Re: Application SSD-10114
Central Coast Quarter
26-32 Mann Street, Gosford (Lot 11 & Lot 12 DP1250131)
Applicant St Hilliers Group

The following comments are provided on the proposed Masterplan:

Figure 4.1: Proposed entry/ exit arrangements ground level

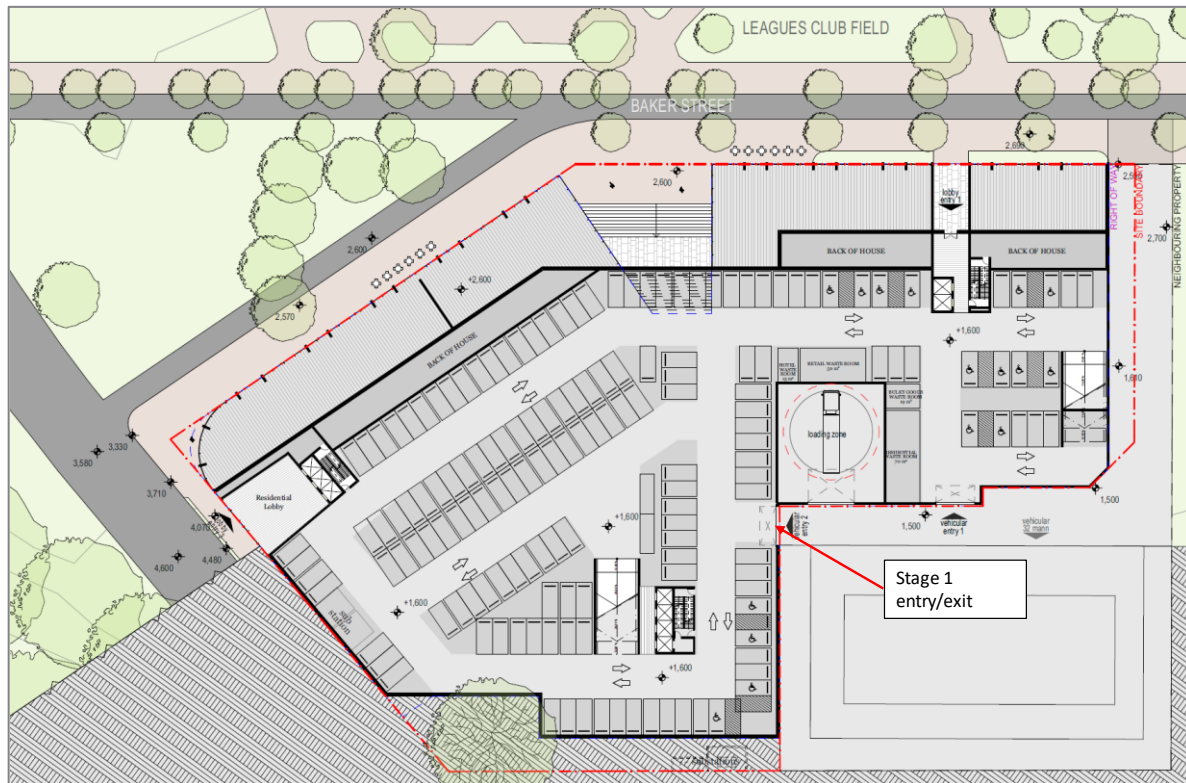
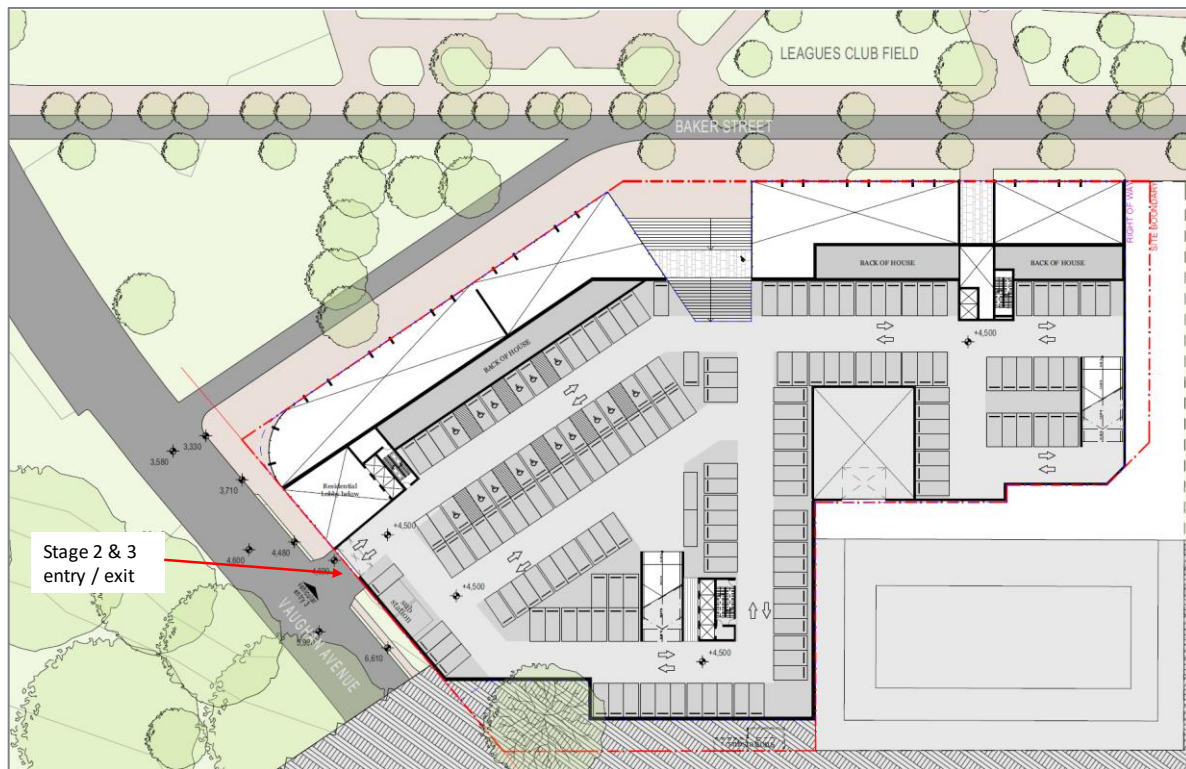
Vehicular access to and from the basement of the proposed (future) hotel on the subject site will be via the vehicle access driveway, constructed in association with the NSW Office of Finance building, which is accessed from the 2-way constructed section of Baker Street.

According to DCP 2018, the Baker Street (extension) is a desired pedestrian boulevard (emergency vehicle access only). This being the case, a turning head is required adjoining the 2-way constructed section of Baker Street to enable 12.5m heavy rigid vehicles (HRVs) to turn around and exit back onto Georgiana Terrace.

The Master Plan is to be amended to accommodate a turning head within Baker Street and the Site (if there is insufficient room in the road reserve to accommodate it). This turning head should be designed in such a way that it clearly delineates the 2-way trafficked portion from the pedestrian boulevard beyond.

1. The recently constructed two-way extension of Baker Street and associated car parking shall be retained.
2. The Master Plan shall be amended to provide for a turning head on the south side of the recently constructed two-way section of Baker Street. The turning head shall be designed for a 12.5m heavy rigid vehicle (HRV). If there is insufficient room to accommodate it, part of the Site is to be dedicated as road reserve as required. The turning head shall be designed to clearly delineate the 2-way portion of Baker Street from the proposed pedestrian boulevard extension to Vaughan Avenue.
3. Baker Street shall be extended from the proposed turning head through to Vaughan Avenue as a pedestrian boulevard with access for emergency vehicles only. This section of Baker Street is to be constructed of materials and signposted to clearly designate it as a pedestrian boulevard.

Figure 8.1: AM/ PM peak hour site generated traffic volumes (completed development)

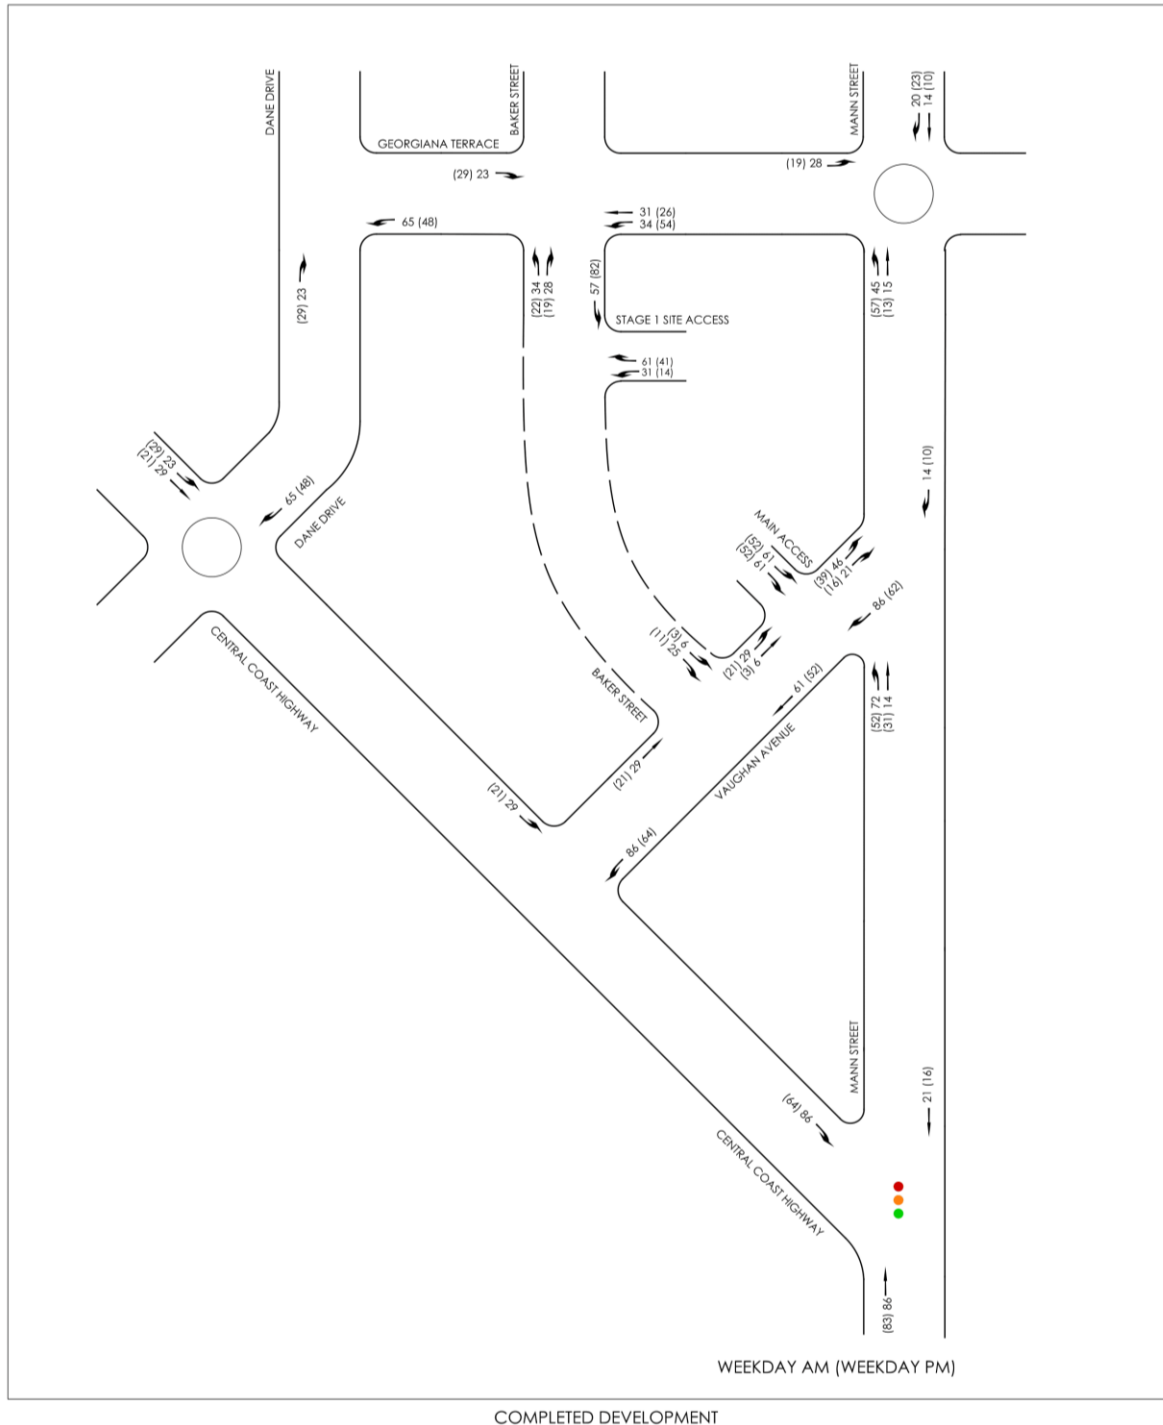
- 8.3.1 Analysis shows Central Coast Highway / Dane Drive roundabout in the PM is operating over capacity now with significant delays particularly to Dane Drive vehicles accessing the roundabout. The Dane Drive approach to the roundabout should be upgraded as part of the masterplan proposed.
- Plans or provisions should be made to upgrade both the Donnison Street and Etna Street railway overbridges as outlined in the SEAR's Attachment A Strategic Plan '*Gosford City Centre Transport Management and Accessibility Plan*'. Both bridges require major upgrading for improved bus, vehicle, pedestrian and cyclists access across the railway corridor. The proposed development will contribute to the need to upgrade both bridges.

C. SWEPT PATH ASSESSMENT

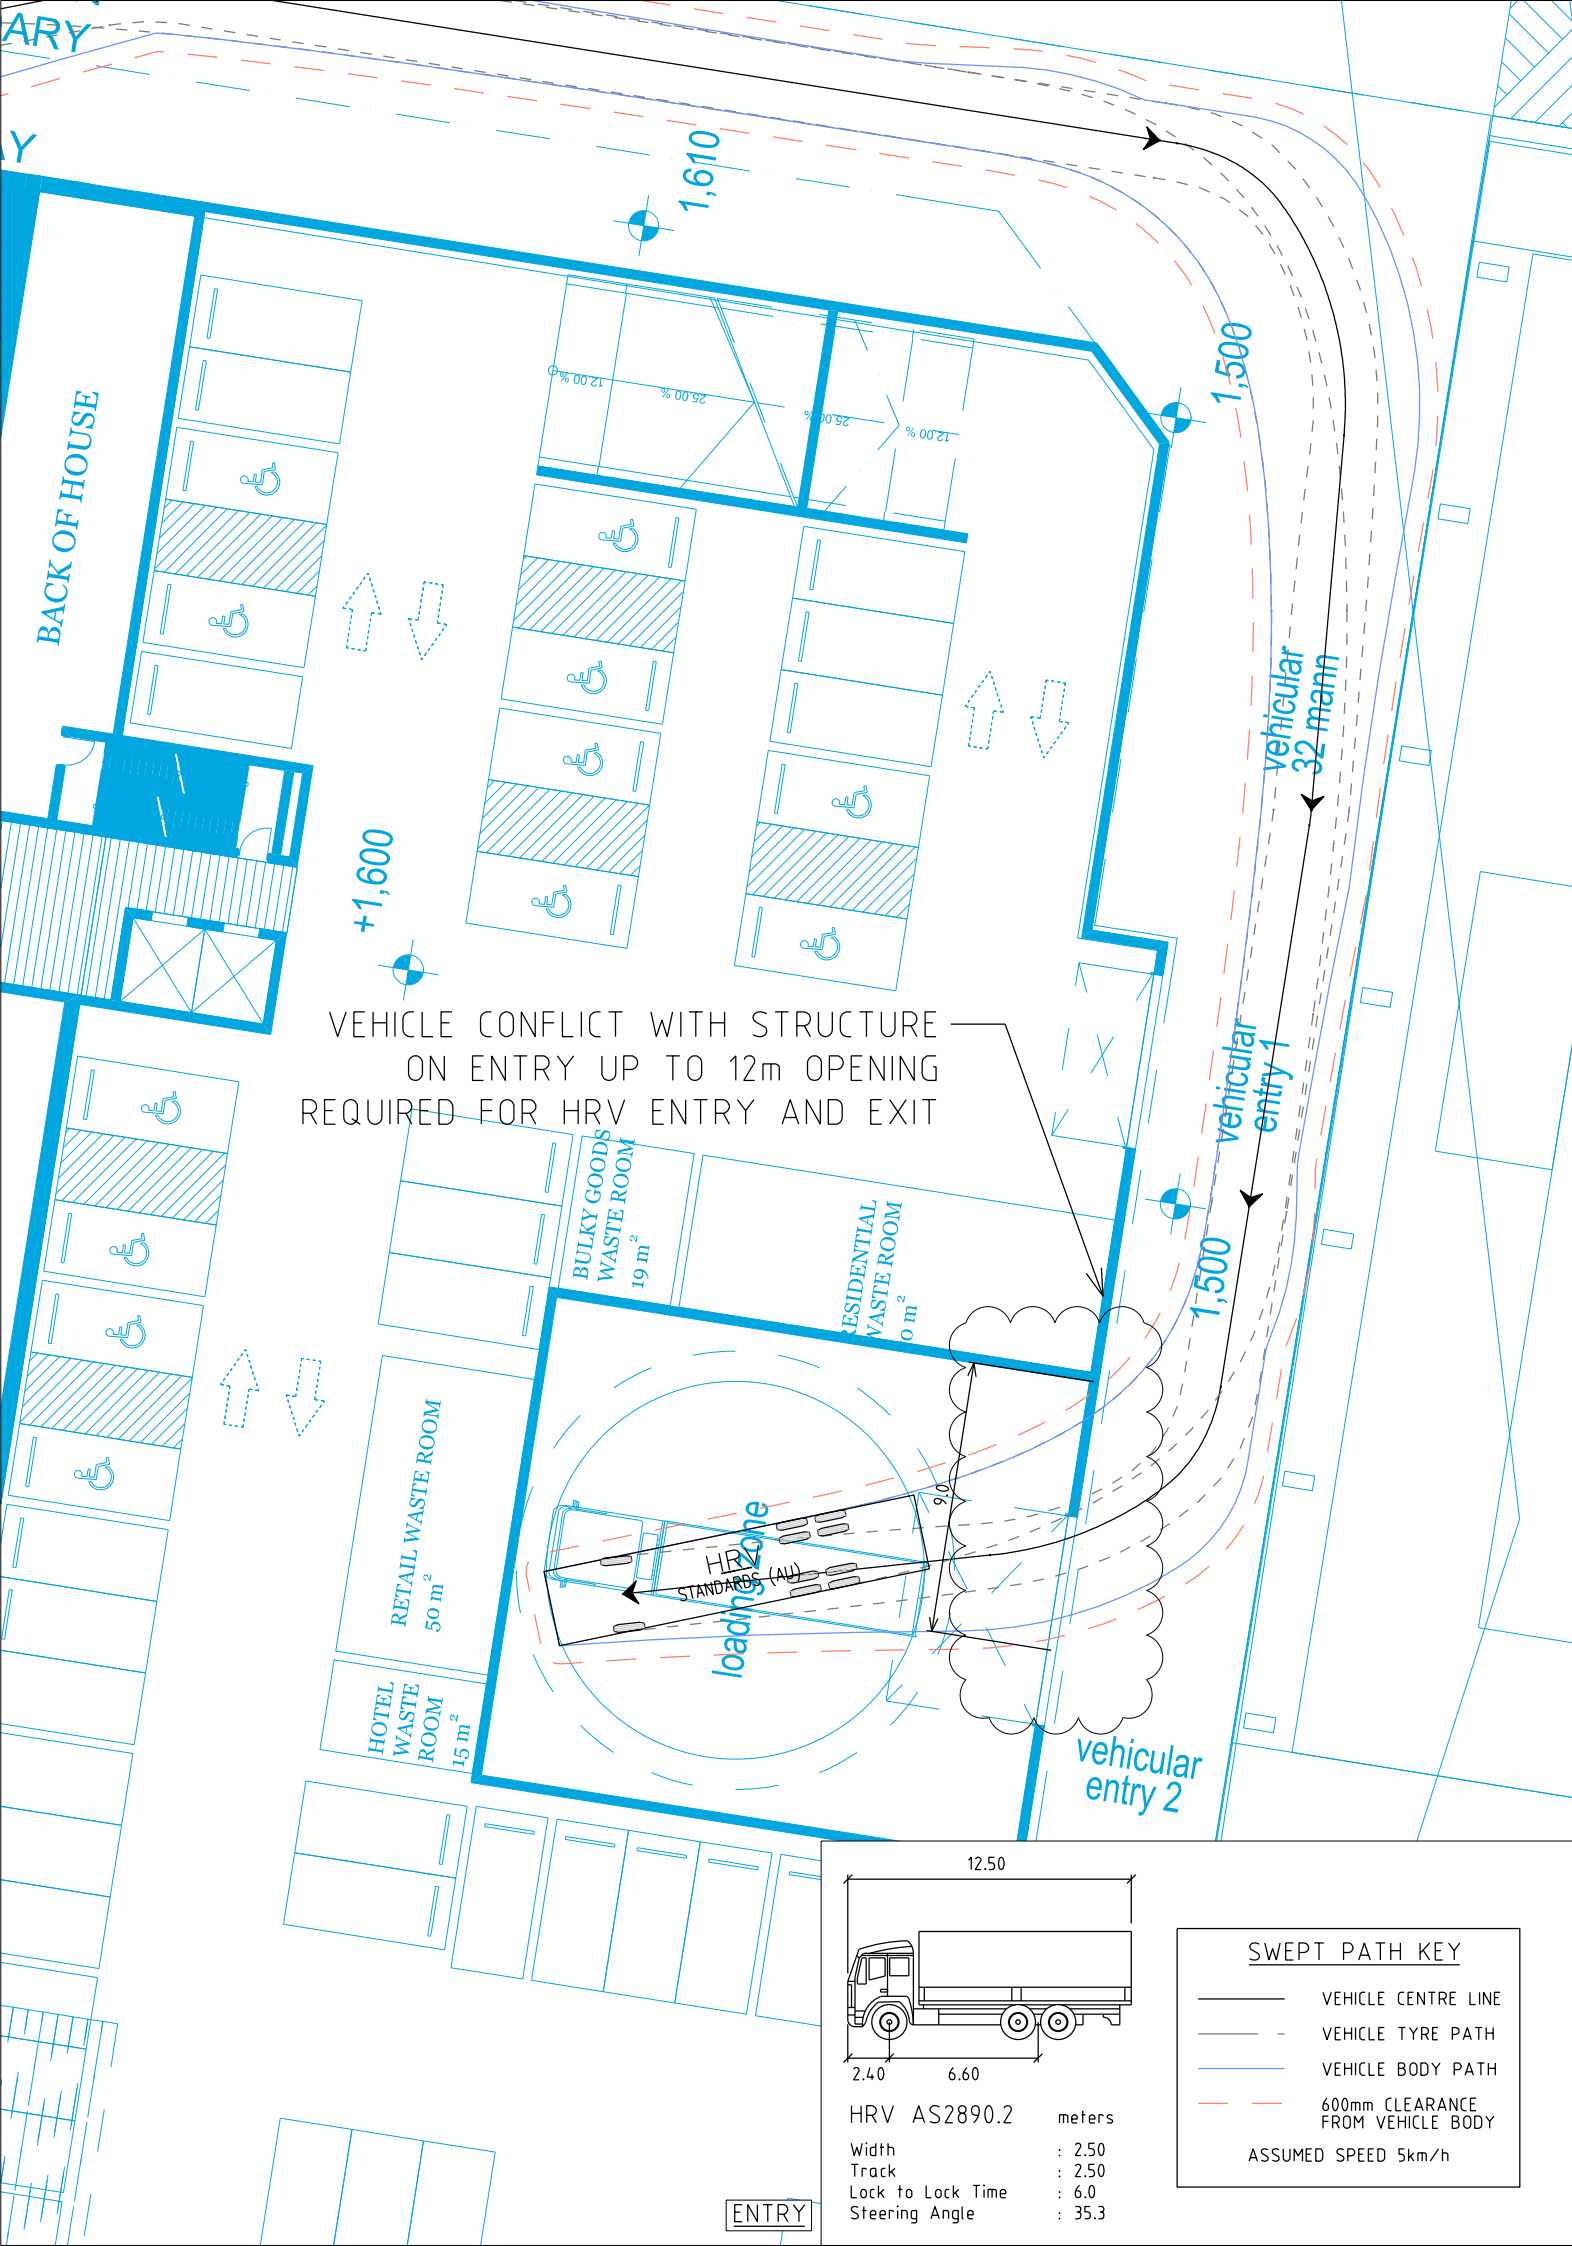
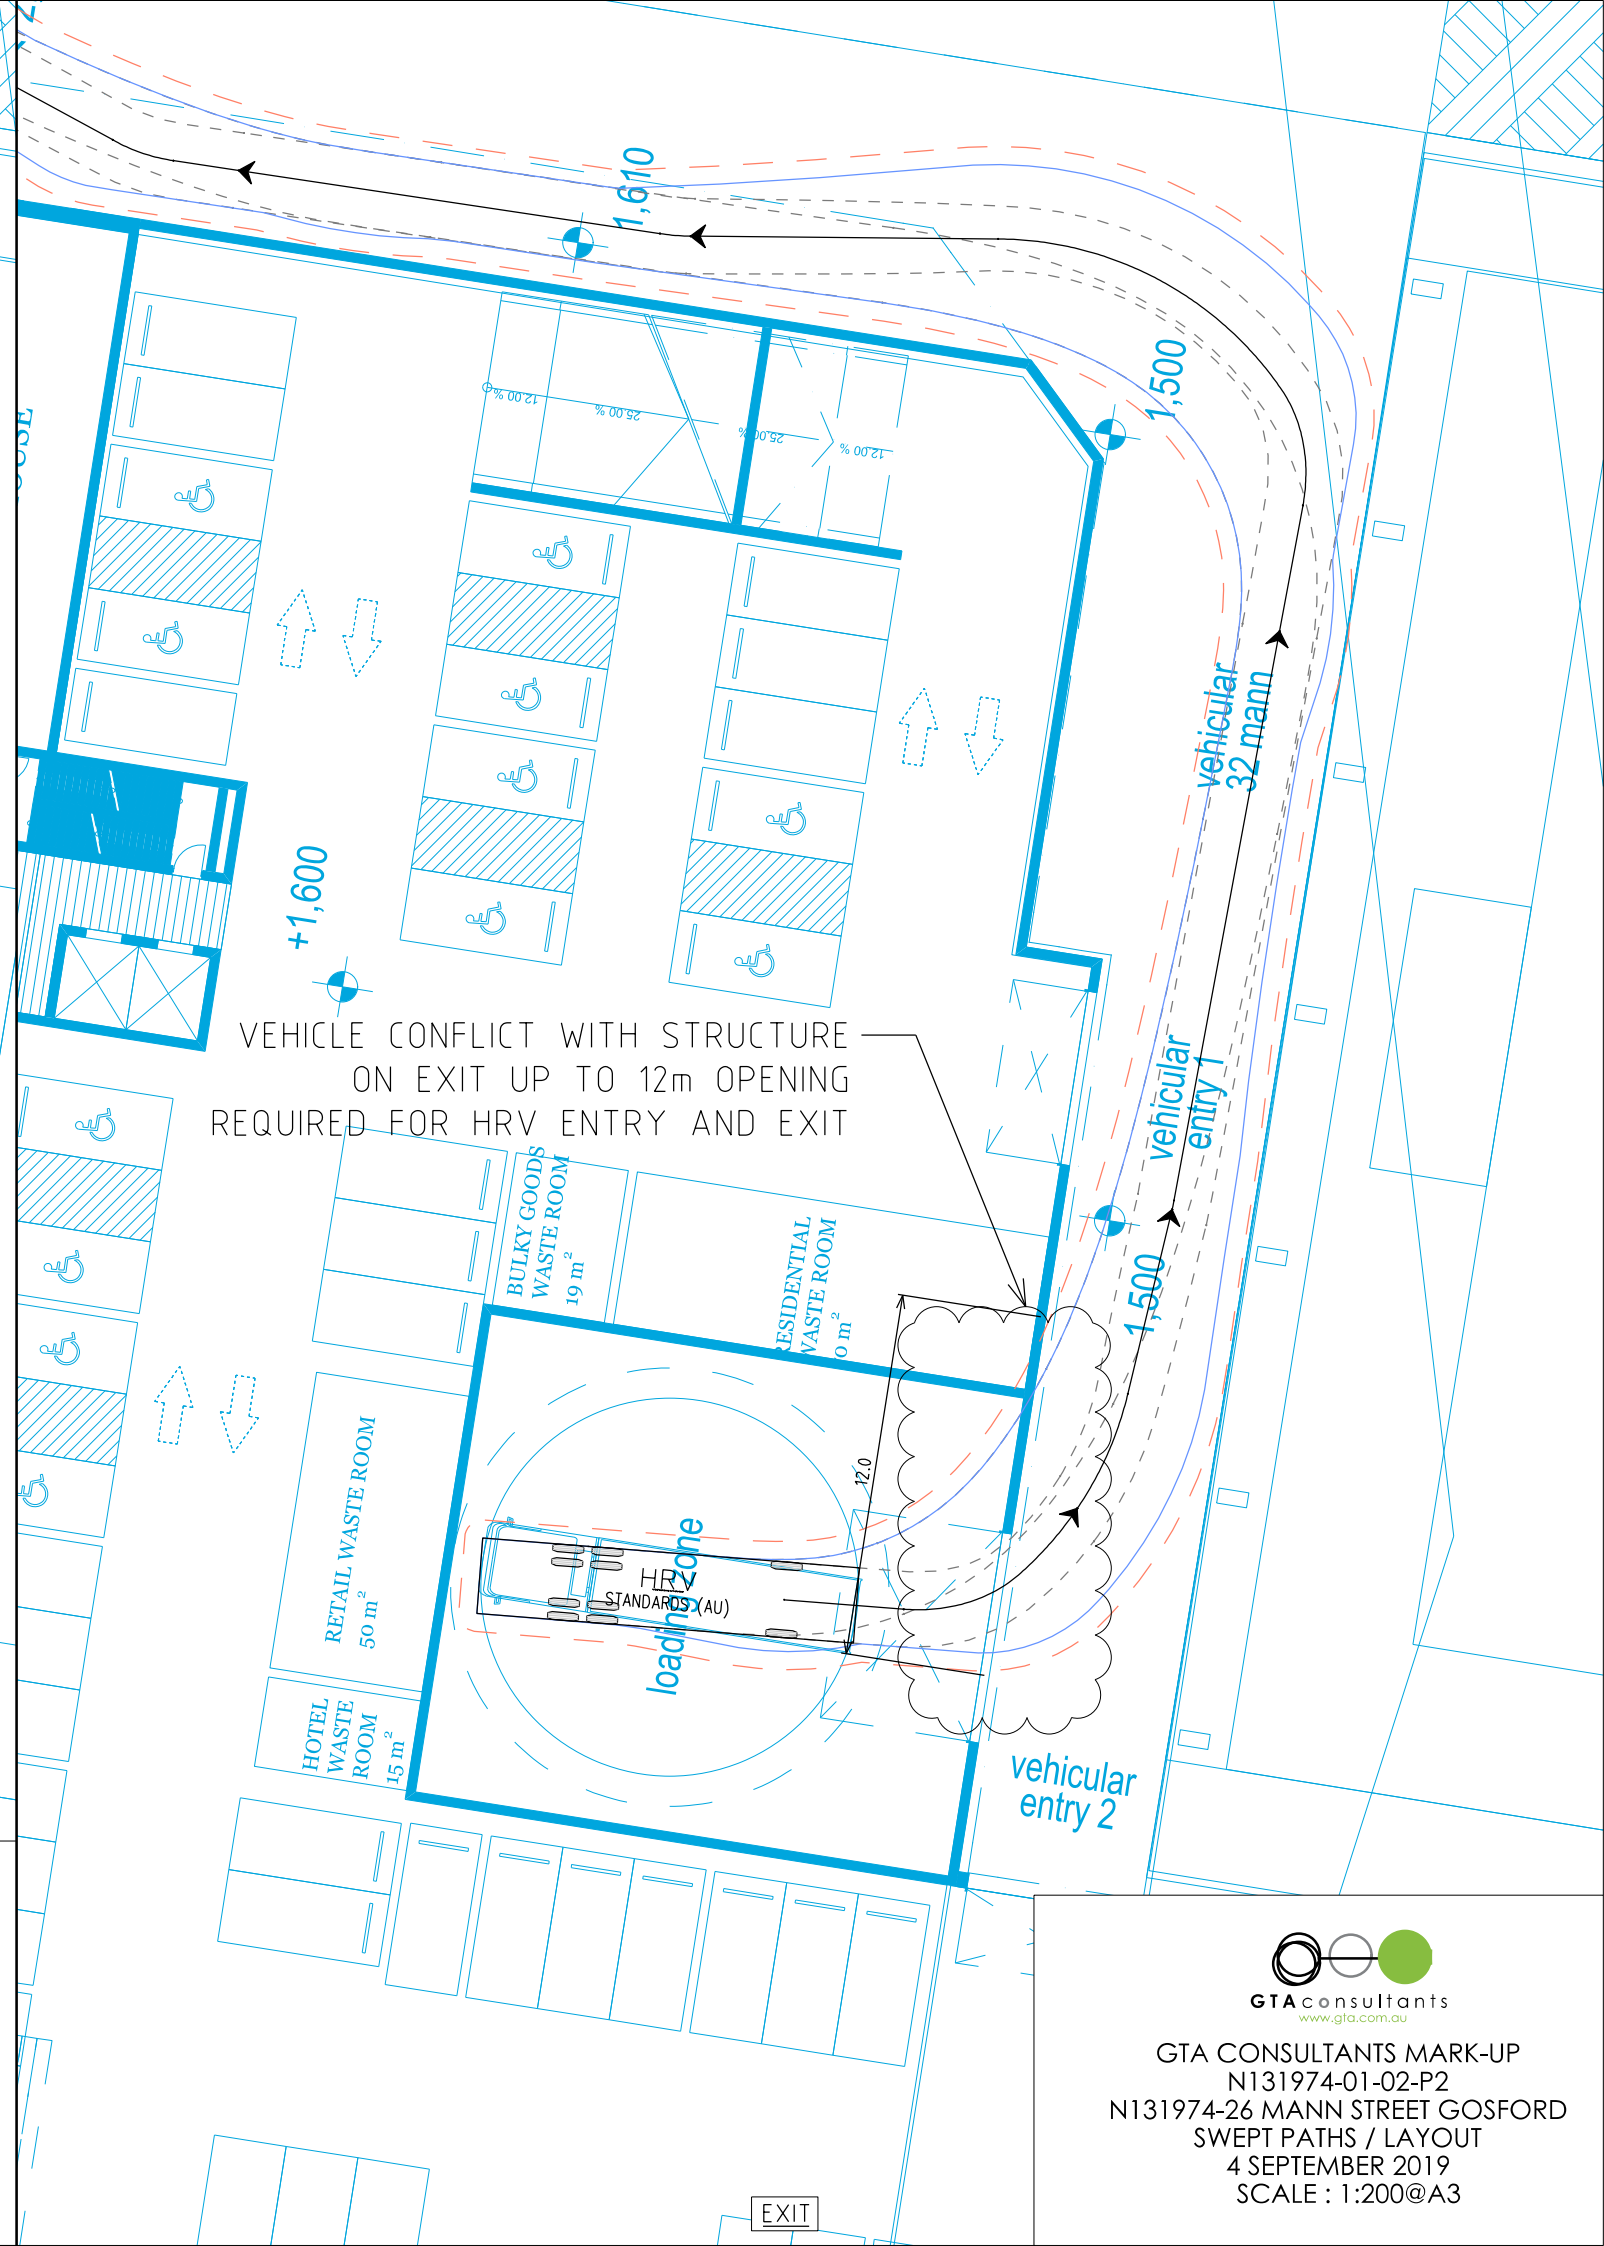
All waste vehicle entry/exit and internal manoeuvring must be demonstrated by swept turning path overlays to AS2890.2 for a rear loading HRV. A minimum 4.0m vertical height clearance must be provided.
